**Consultation Response from KC,
Trees****2022/91880 The Richardson Arms, 684, Bradford Road, Oakenshaw, BD12 7EN****Erection of residential development****Date Responded: 30/09/22****Responding Officer: Nick Goddard****Responding Ref:**

| Proposed Site Plan |

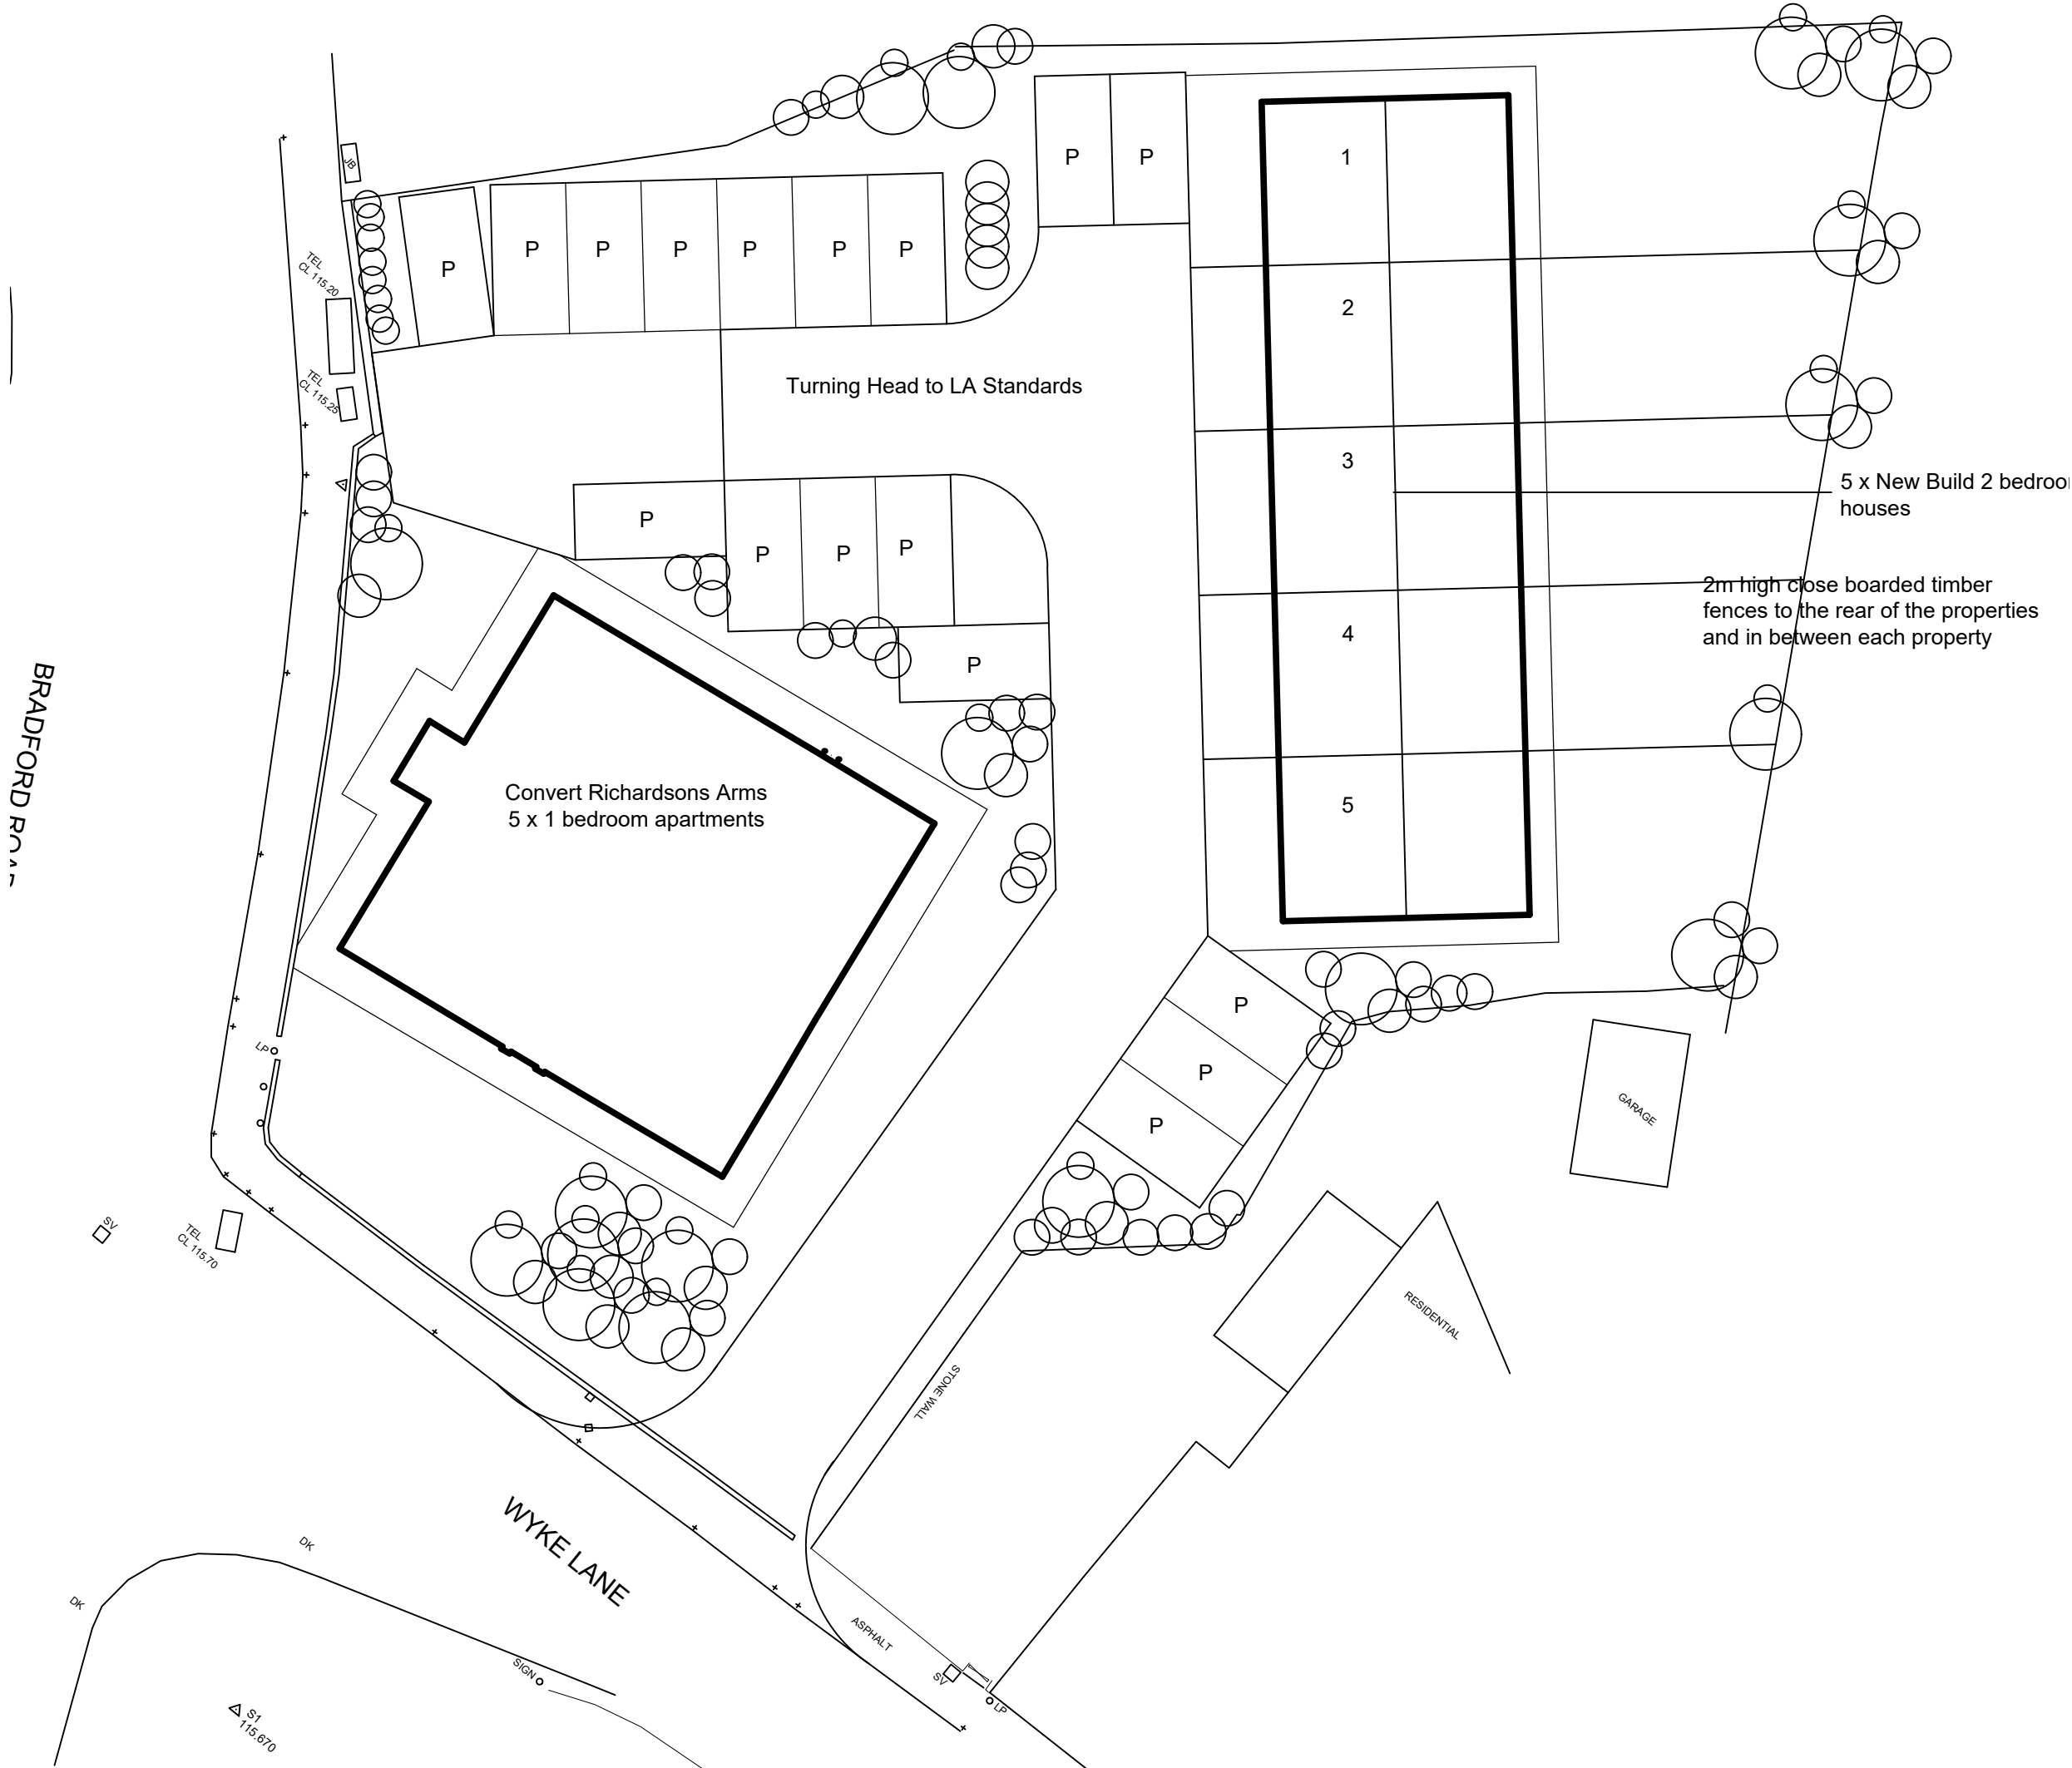
The proposals include parking areas and a plot (1) close to the boundary of the site. The site's existing hardstanding does make it possible with careful controls to incorporate parking areas adjacent to the boundary.

The main concerns are the potential impacts on the roots of adjacent trees of the position of plot 1 and details need to be provided as whether this is possible without causing harm to the trees.

The overhanging canopies of the trees adjacent will require some management and pruning to enable the proposed development. Details of the pruning required should be included in submitted tree information.
